Reference No:	2025/44/93548/E
Site Address:	land opposite, 6, Long Moor Lane, Shelley, Huddersfield, HD8 8LY
Description:	Discharge of details reserved by condition 5 (swept path analysis) on previous permission 2023/92165 for demolition of existing outbuilding and erection of detached dwelling
Recommending Officer:	Elenya Jackson

DECISION – Discharge of Condition 5 - Approved

SWEPT PATH ANALYSIS.
SCALE 1:200.

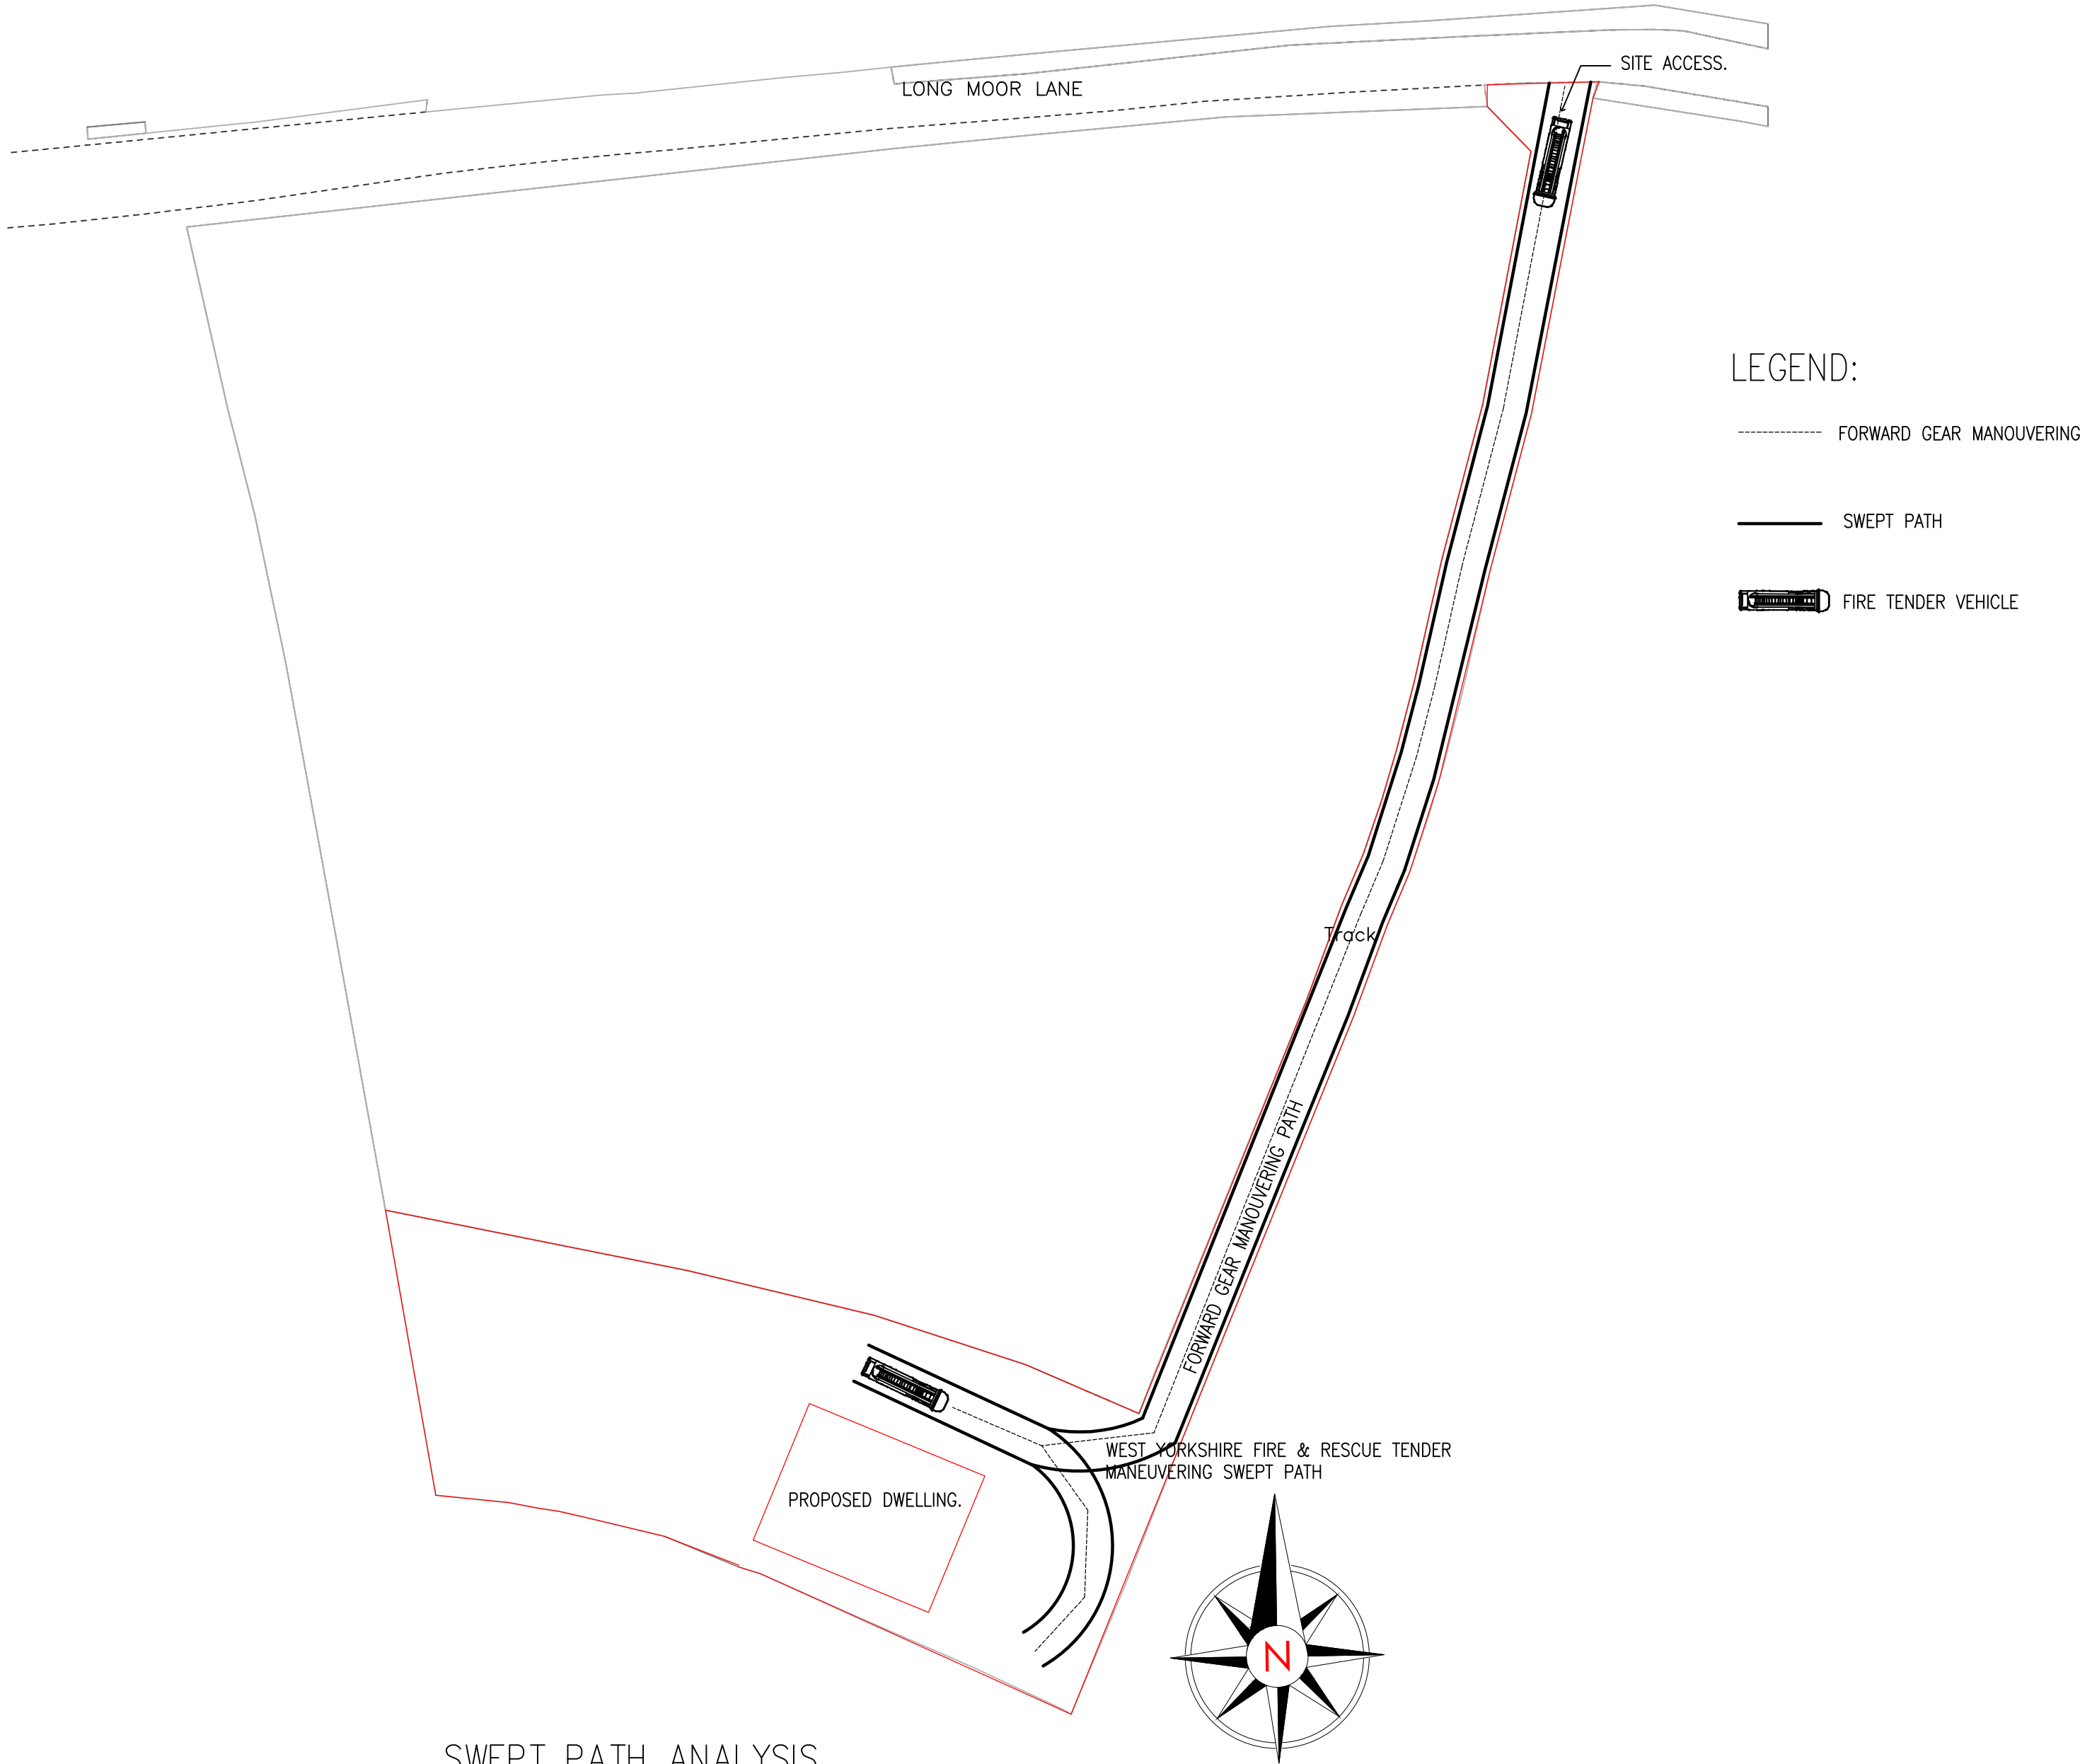
The details contain the assessment that a fire tender is able to turn within the site. The details have been reviewed by KC Highways Development Management who are satisfied that the submitted analysis is acceptable.

The submitted information is therefore acceptable for the purpose of discharging condition 5.
